Subject: RE: Littlehampton - Drainage plan Rev2

I can confirm that all of the queries raised have been closed off within your drawing (Rev 3 v2) to my satisfaction.

The final engineering comments are as follows; (See below)

Project					LITTLEHAMPTON				
Title					SURFACE DRAINAGE PLAN				
REV DRAINAGE PLAN 3									
Drawn			Dwg. Chk.		Date Chk.		Approved		Date Approv.
1:100@A1			Status			FC		Rev	
								*	
Drawing No.									
003

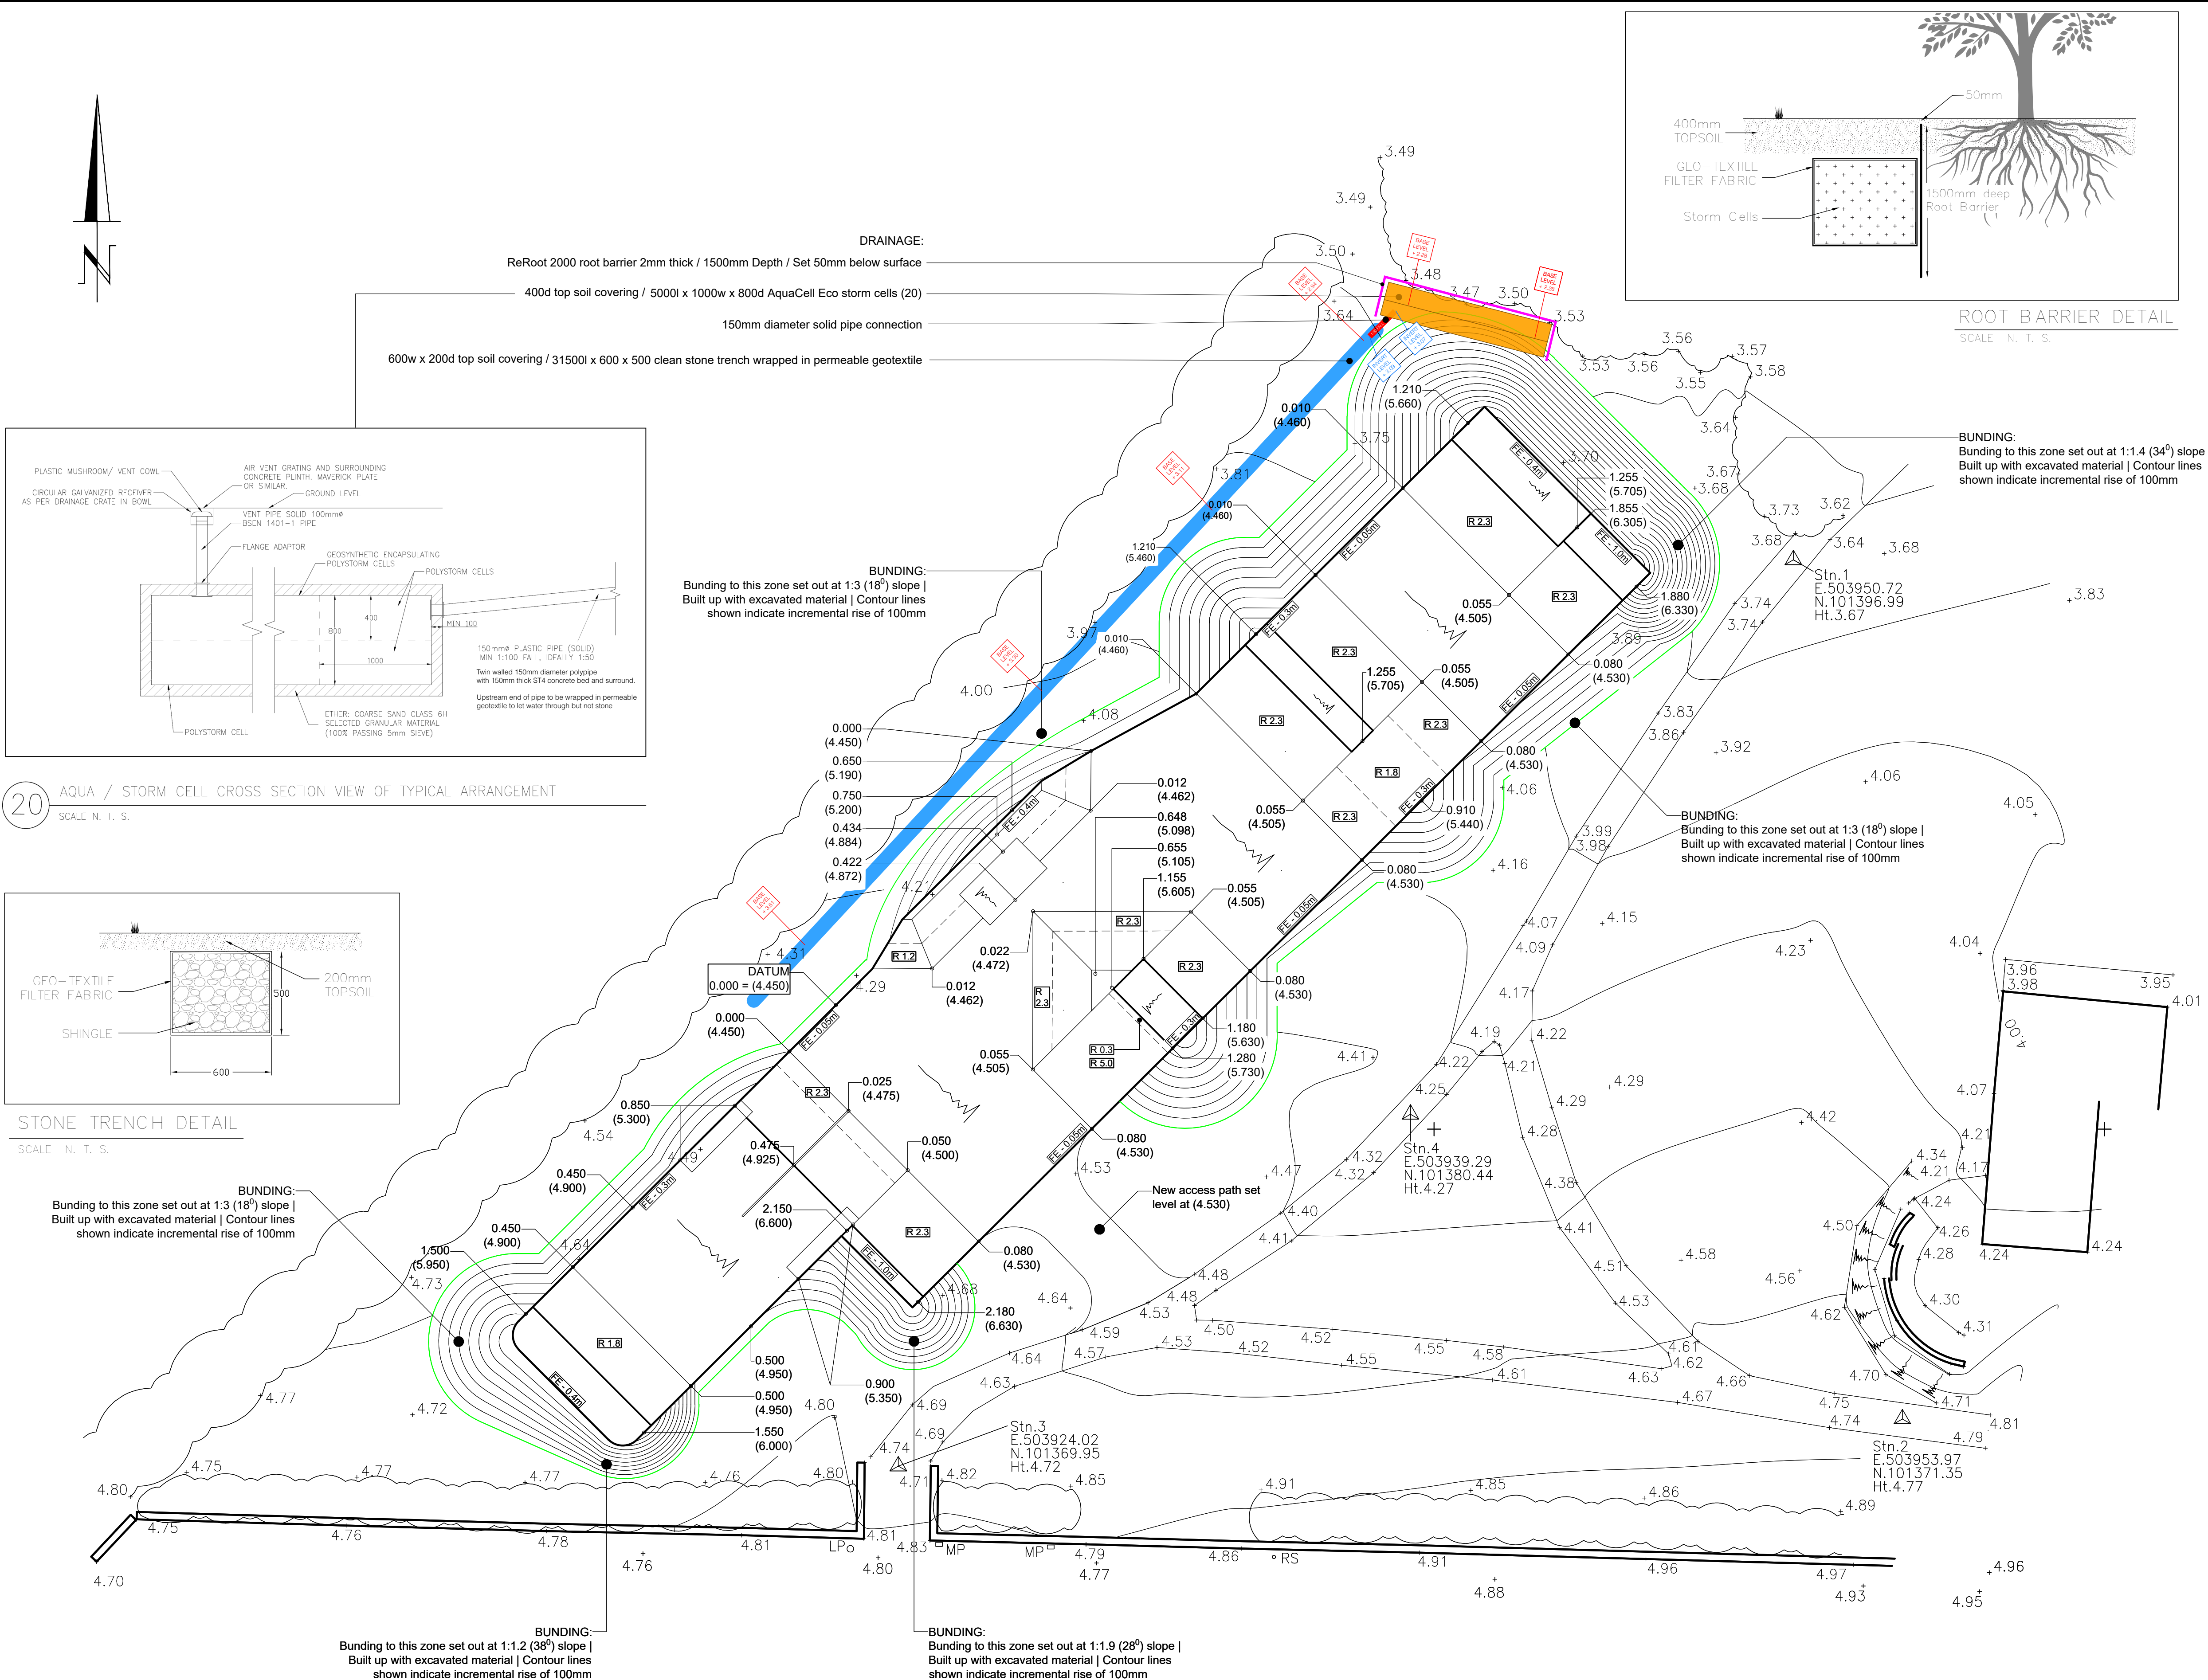
1. They will need to confirm that there will be no structural stability issues with the skate park structure or bunds, as result of the proximity of the soakaway trench/crate systems.

2. The bunds adjacent the trench soakaway may creep over the trench soakaway, over a period of time – would they consider reinforcing the bunds in this area with geogrid mesh or similar?

3. The trench soakaway laid at the gradient proposed will act as conveyance of water but will achieve infiltration on route due to the nature of the ground conditions. Please specify proposed base levels of the trench soakaway at say every 5 metres. Please also provide a construction detail in line with the descriptive text ie. 500x500mm clean stone fully wrapped in permeable geotextile and 200mm of topsail laid over the top.

Amended dwg attached with base levels *Please provide construction detail drawing. Okay*

4. Specify pipe link between trench and crate soakaway as 150mm diameter as opposed to 100mm, twin walled polypipe with 150mm thick ST4 concrete bed and surround. Upstream end of pipe to be wrapped in permeable geotextile to let water through but not stone. Indicate pipe invert levels upstream and downstream.

Noted and confirm change to 150mm and added spec to construction detail. *Please provide invert levels upstream and downstream. Okay*

5. Provide a further layer of 400mm deep crates to increase crate depth to 800mm, and provide 400mm of topsoil above. Crates to be wrapped in permeable geotextile. Stone surround to crates is not required. Specify base level of crates. Indicate precise model of polystorm crate ie. polystorm standard (44t/m2 compressive strength). Alter the construction detail to suit.

Noted and confirmed - datasheet of crates attached. 10 additional crates included to depth of 800mm. Base level added. *Please state on plan that the crates will be aquacell eco. Please change levels on plan so that crates are formed on a level base. Okay*

6. An impermeable root barrier will be required to protect the crate soakaway from root intrusion due to proximity of vegetated area on the north side. Provide construction details, etc of the proposed arrangement. The permeable membrane wrapping to the crates is not considered sufficient to fully prevent root intrusion hence the additional measure being required.

Noted - root barrier we propose to use is attached. *Please include root barrier on construction detail, this must include details of the depth below surface that this root barrier starts, and how far down the barrier extends. Okay*

I can confirm there will be no structural stability issues. *Okay. Okay*

We would not recommend this adjacent to the skatepark. We have moved the trenches away from the bunds as much as is possible. *Okay. Okay*
